From: Pat Nicholson
Sent: Wednesday, August 07, 2019 11:51 AM
To: Chelsea Benner
Subject: RE: CB-19-00012 Hunt Parcel Combination

From: Chelsea Benner
Sent: Wednesday, August 07, 2019 11:36 AM
To: Taylor Gustafson; Pat Nicholson; Holly Erdman; Jesse Cox
Subject: CB-19-00012 Hunt Parcel Combination

Proposed  
820 HUNTRICK  
DR  
SITE PLAN  
1" = 100'

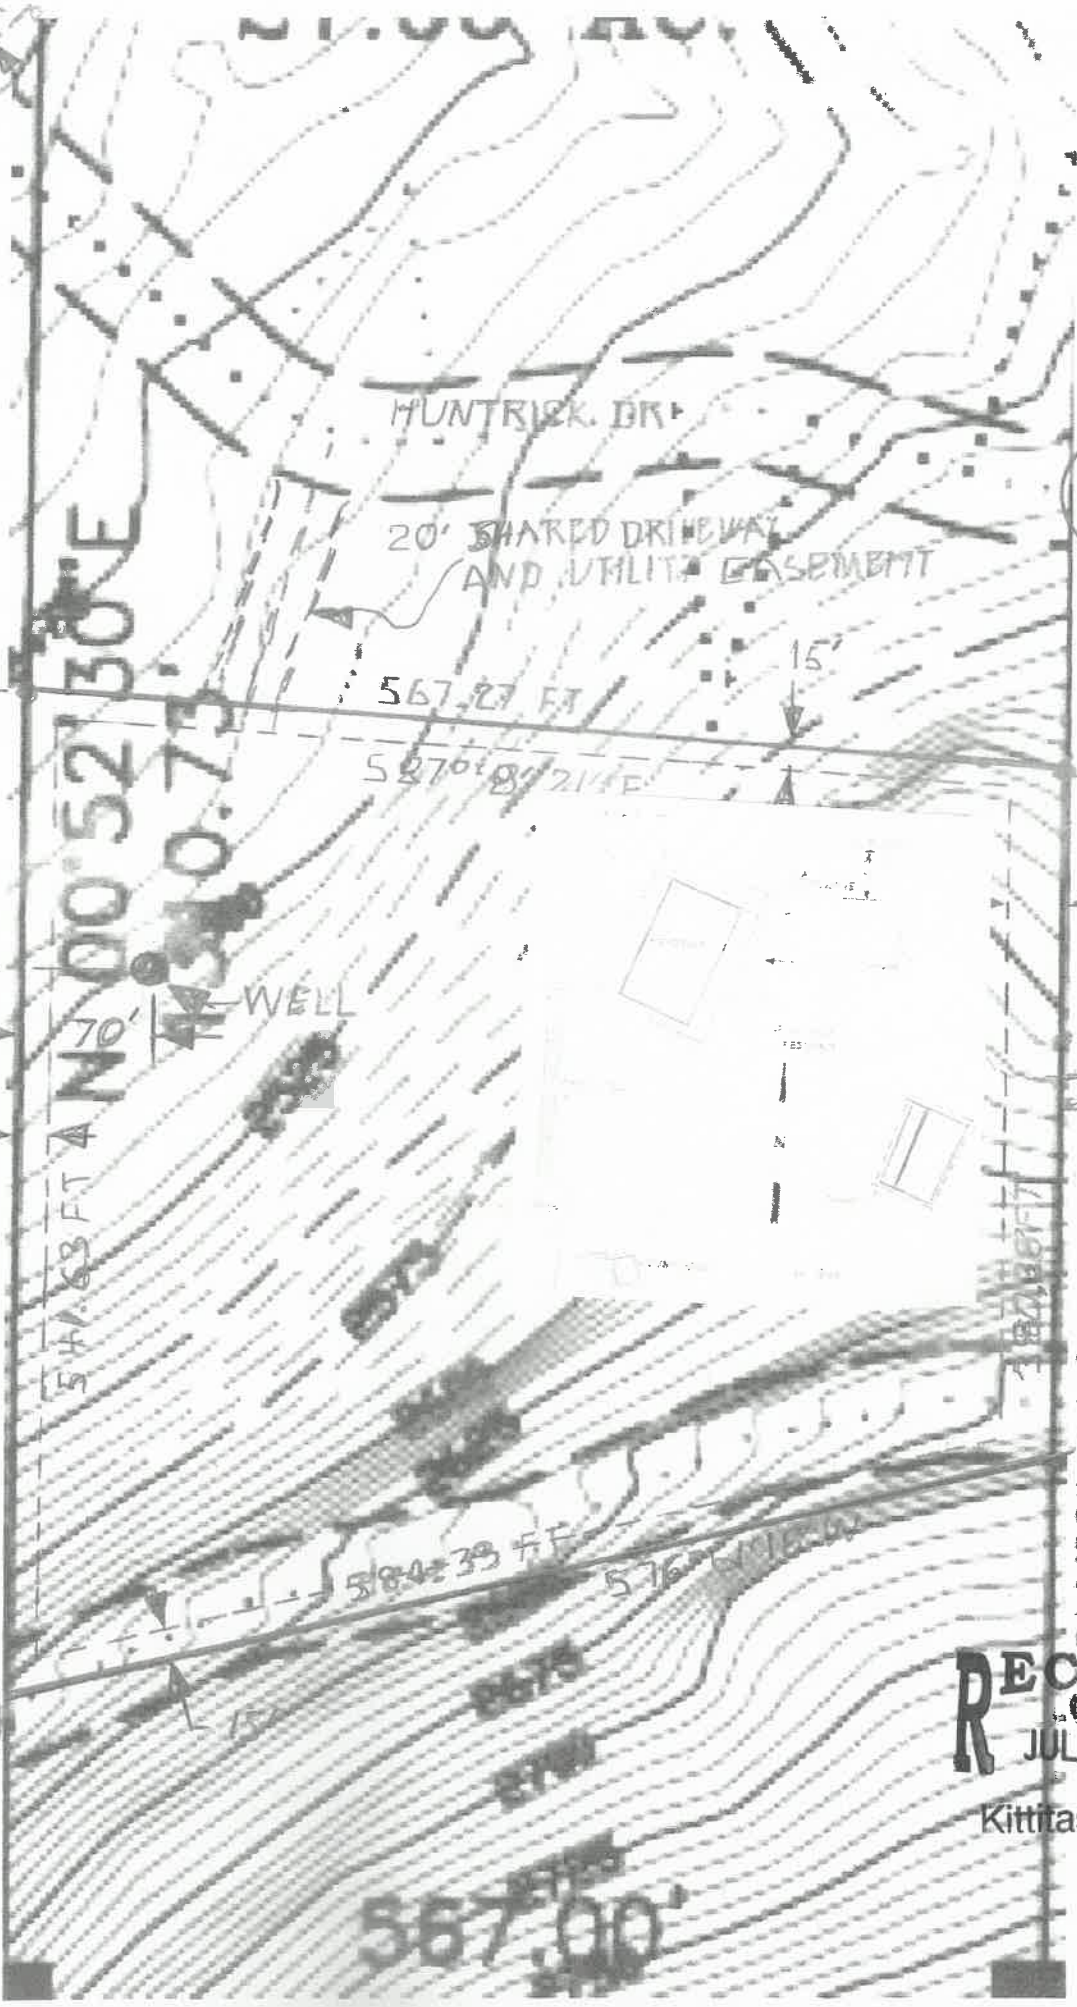
Driveway to meet current IFC Appendix D and County Public Works standards.

Addressing visible from road
